Our Ref: EP/173/18/HH
Your Ref:

Town & Country Planning Act 1990 (as amended)
Town & country Planning (Development Management Procedure) (England) Order 2015
Application for Planning Permission for Works or Extension to a Dwelling

Development Front and rear single storey extensions
Location 27 Vermont Way East Preston

AR-133-01

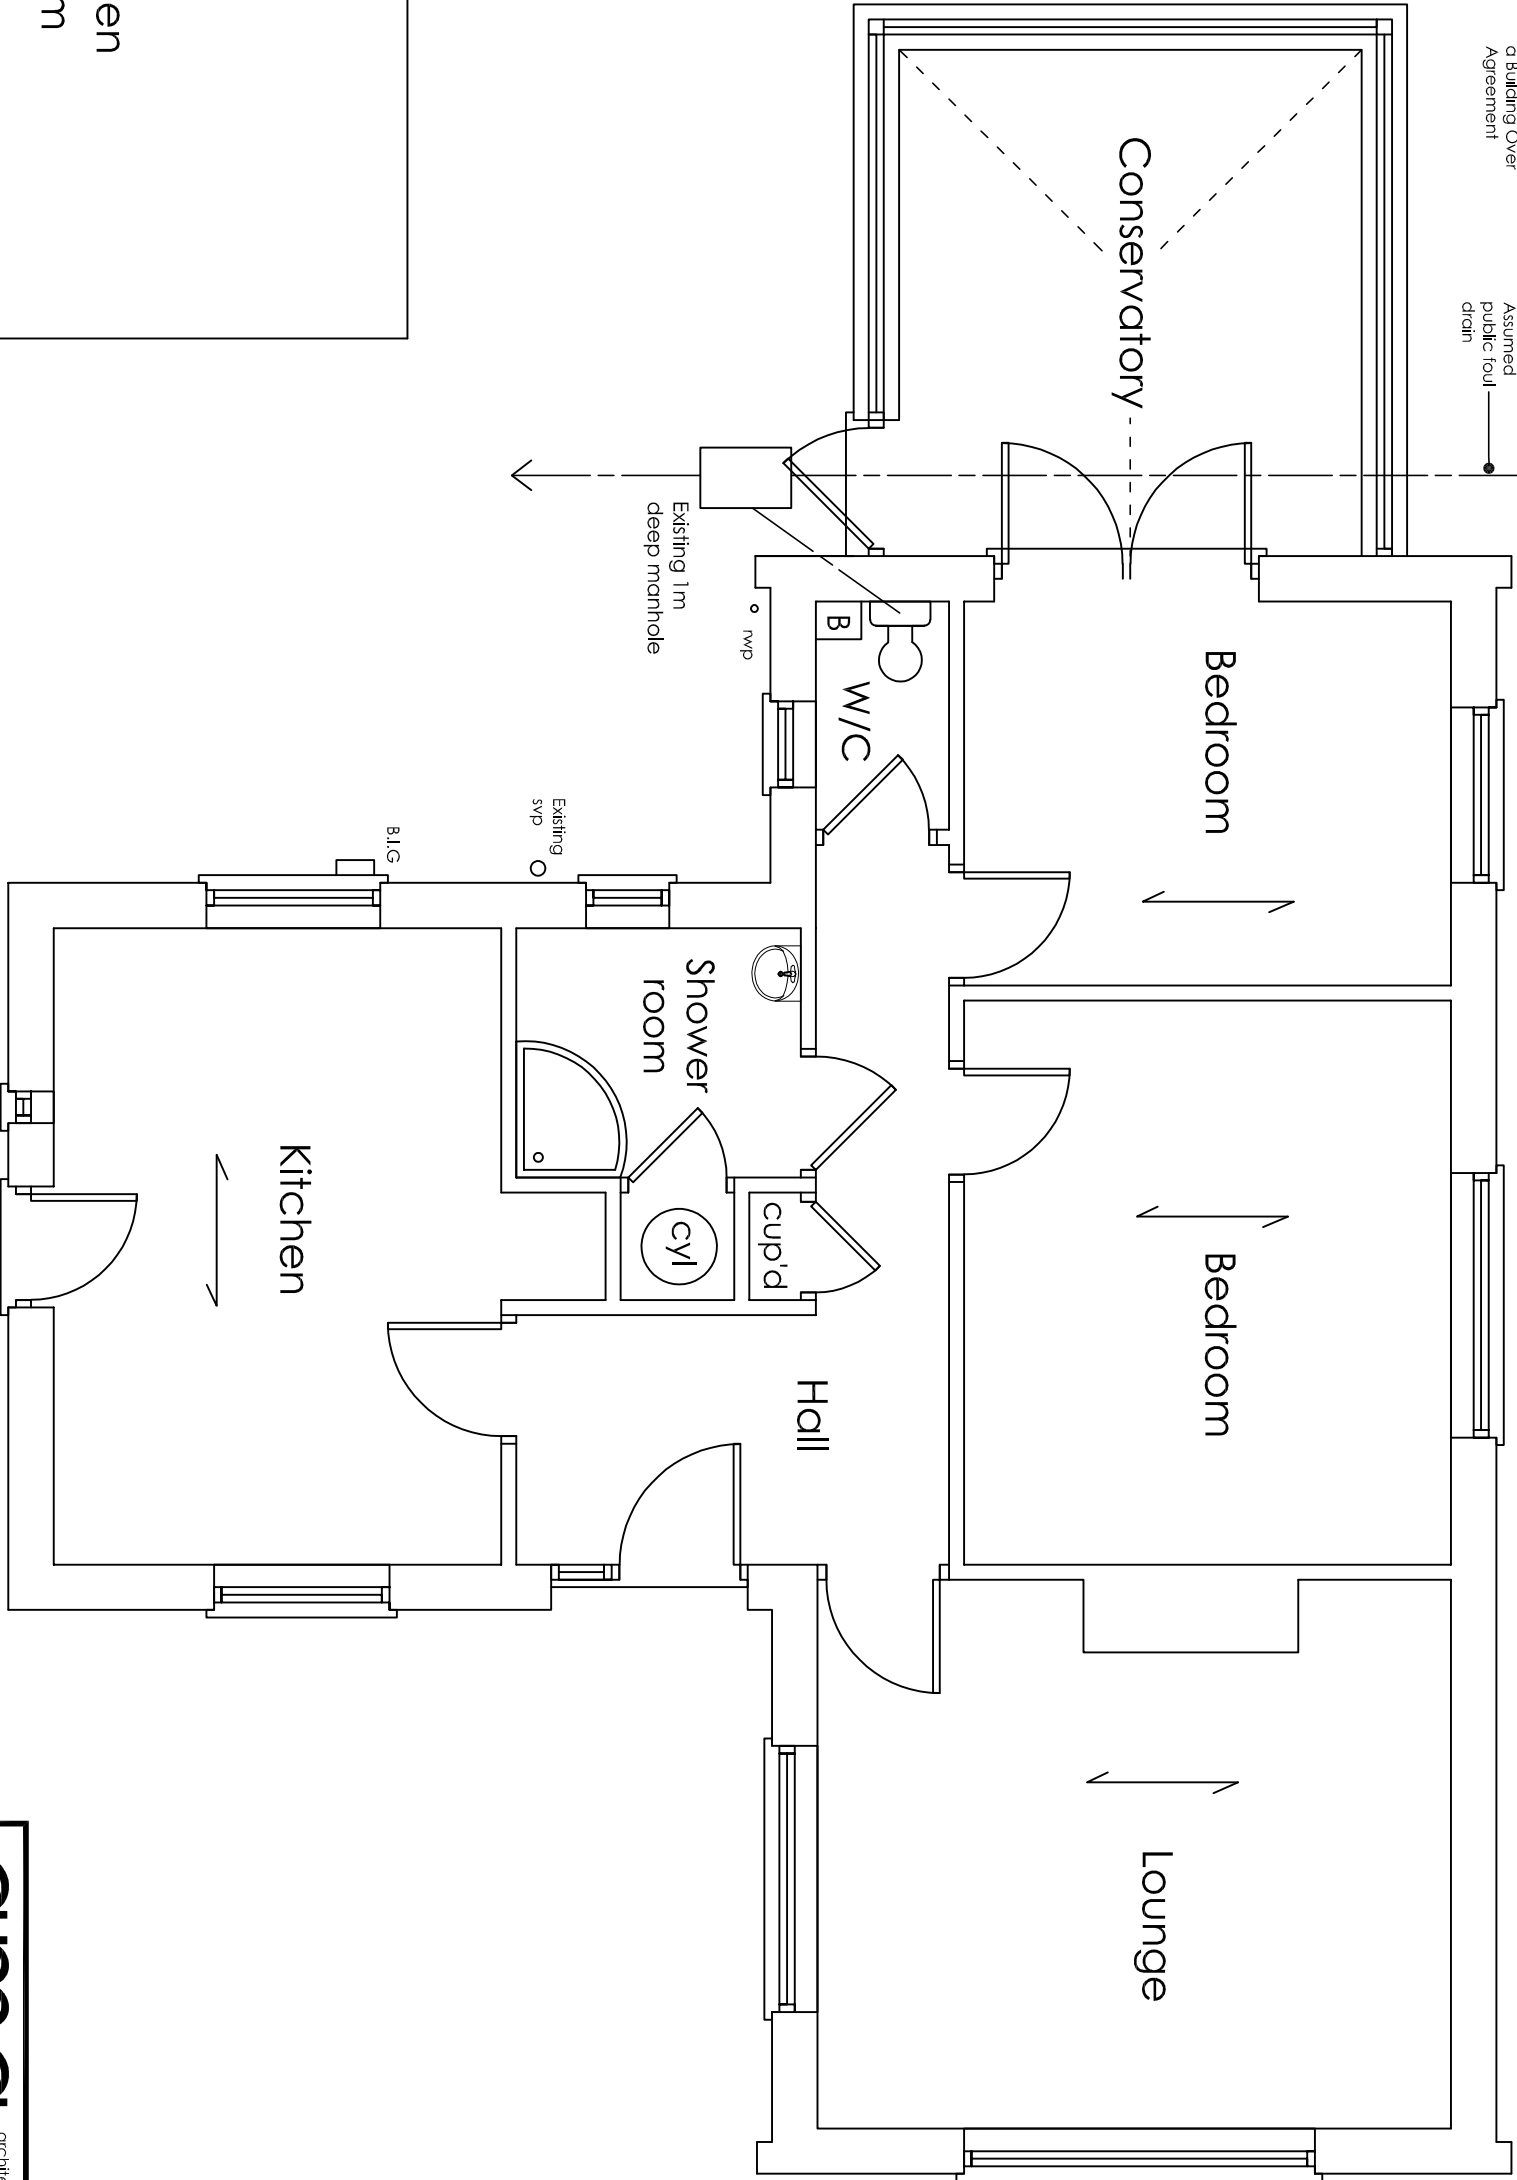
Plans Inconsistent

The building lines do not match between the proposed north elevation and the existing and proposed ground floor plan.

SITE PLAN 1:500

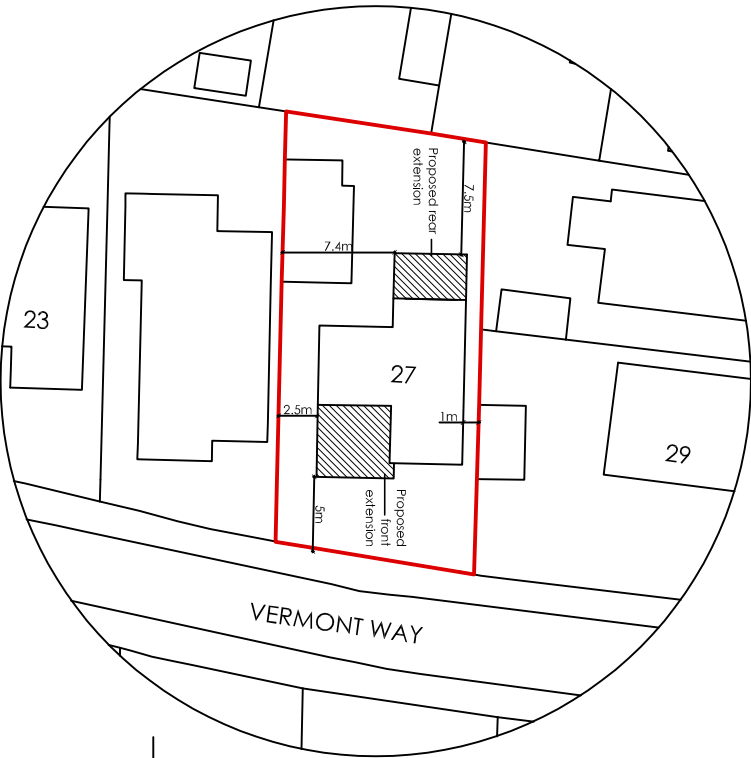
Block Plan

You are required to annotate the dimensions from the proposed extensions to the site boundaries.
